CITY OF ALBUQUERQUE

August 31, 2018

RE: **Bosque Antigua
Gabaldon Dr NW
Grading Plan Stamp Date: 8/27/18
Drainage Report Stamp Date: 8/27/18
Hydrology File: J12D015**

Based on the submittal received on 8/27/18 the above-referenced submittal is approved for Preliminary Plat Only. J12D015 is the correct file number for this project; the previous letter heading was incorrect.

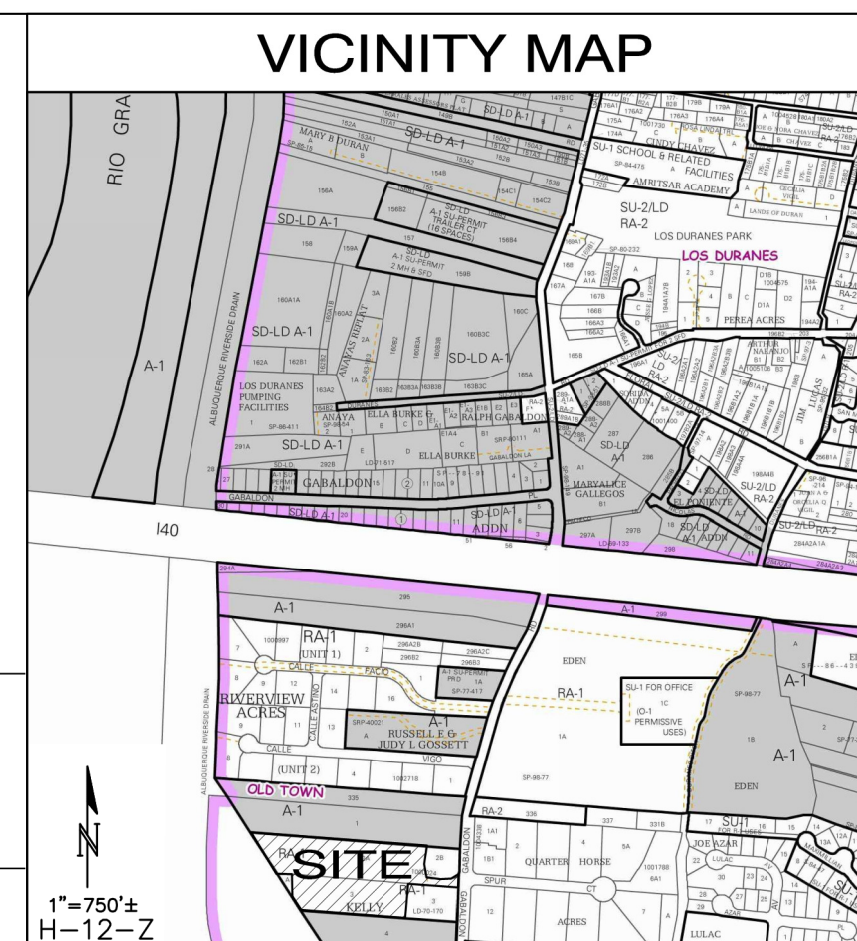
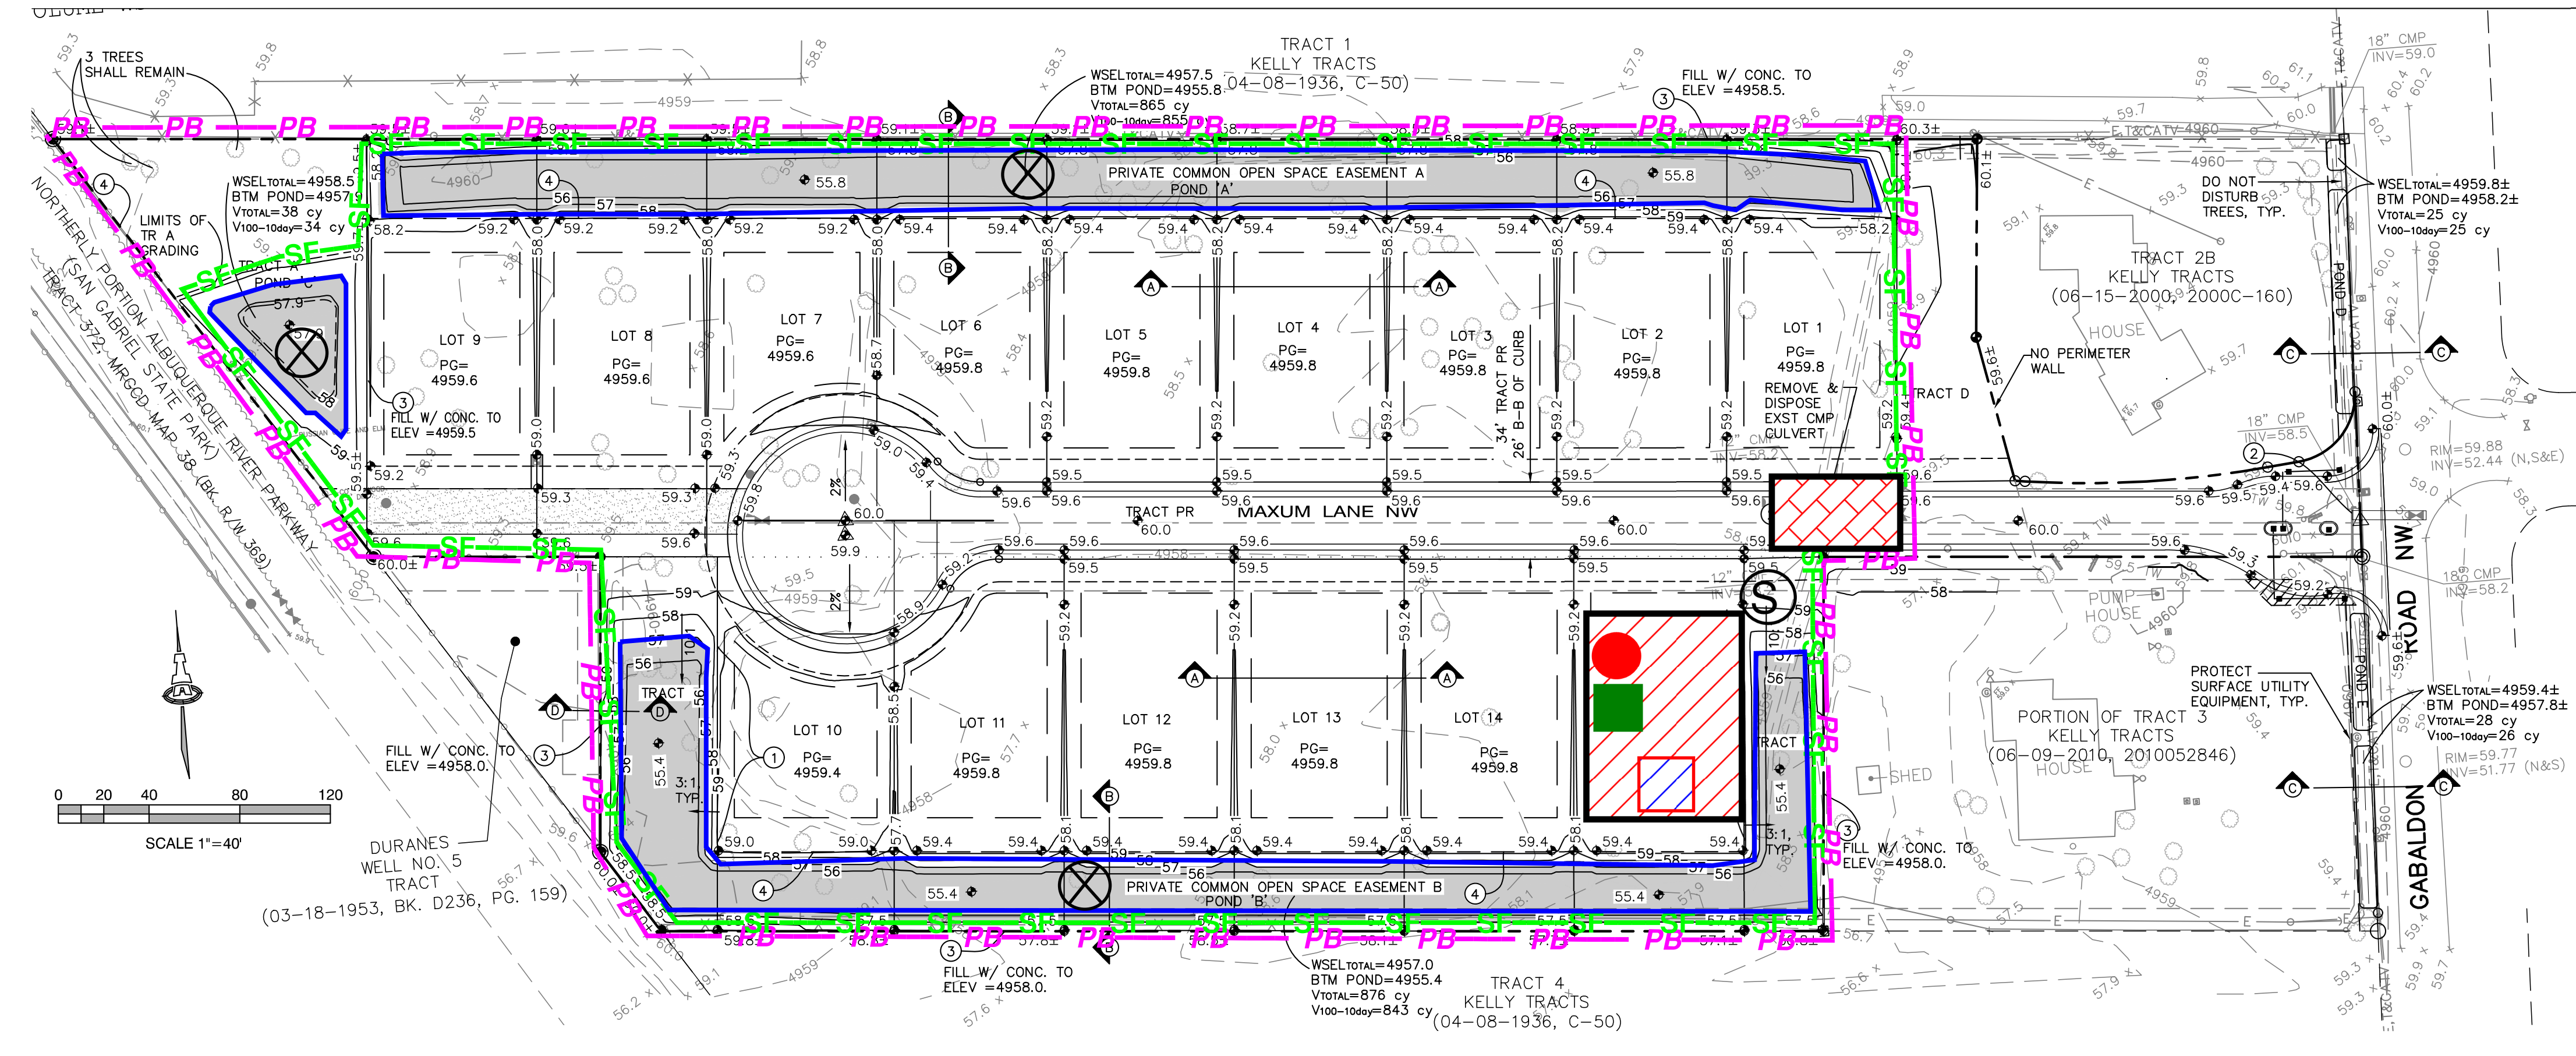
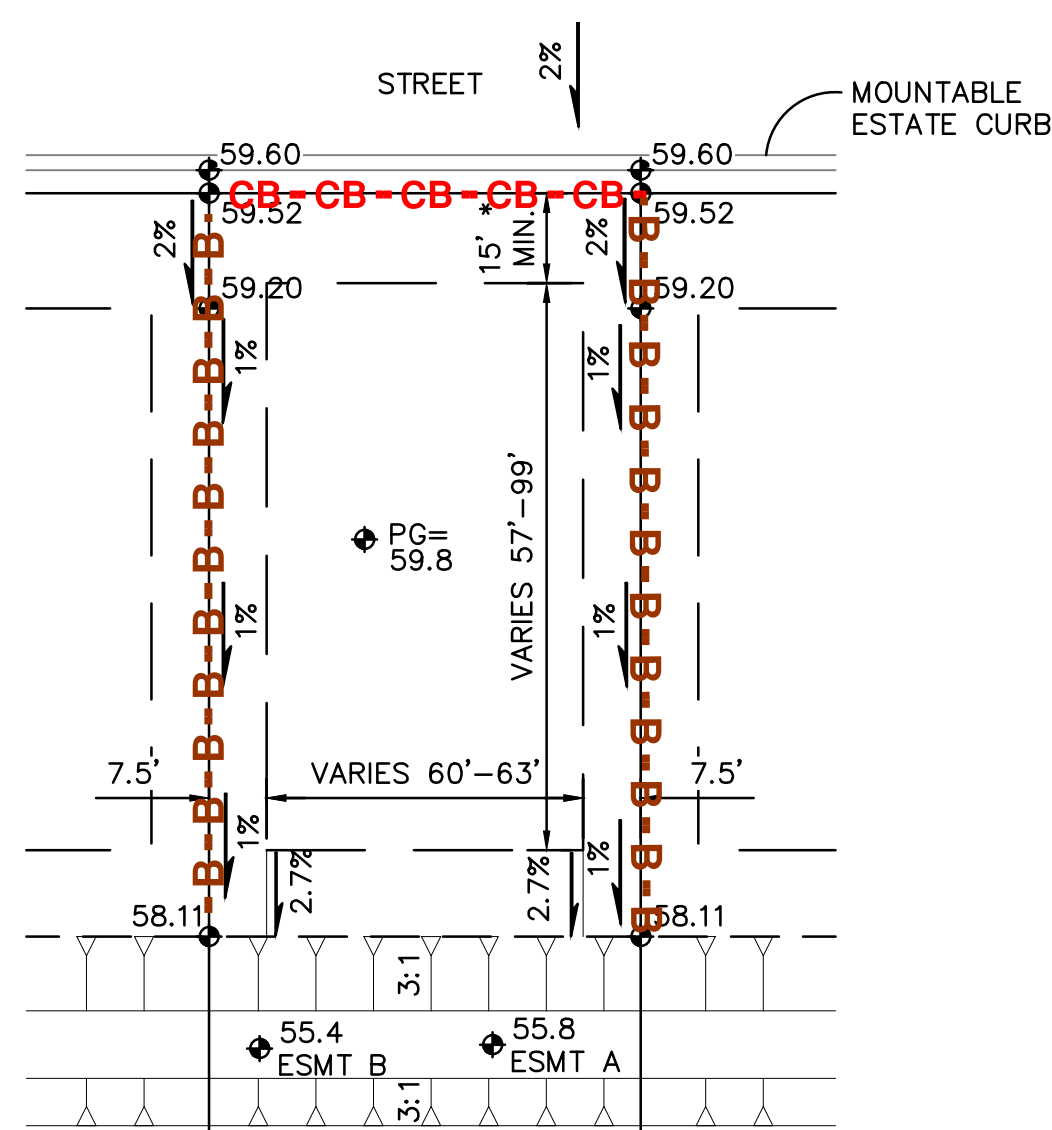
1. Pond A WSE is shown as 4957.5', but described in the drainage report as 4957.0'. Pond B WSE is shown as 4957.0', but described in the drainage report as 4957.5'. Pond B capacity is shown as 865cy, but described in the drainage report as 876cy Please correct.
2. This project requires an ESC Plan, submitted to the Stormwater Quality Engineer (Curtis Cherne PE, ccherne@cabq.gov or 924-3420).
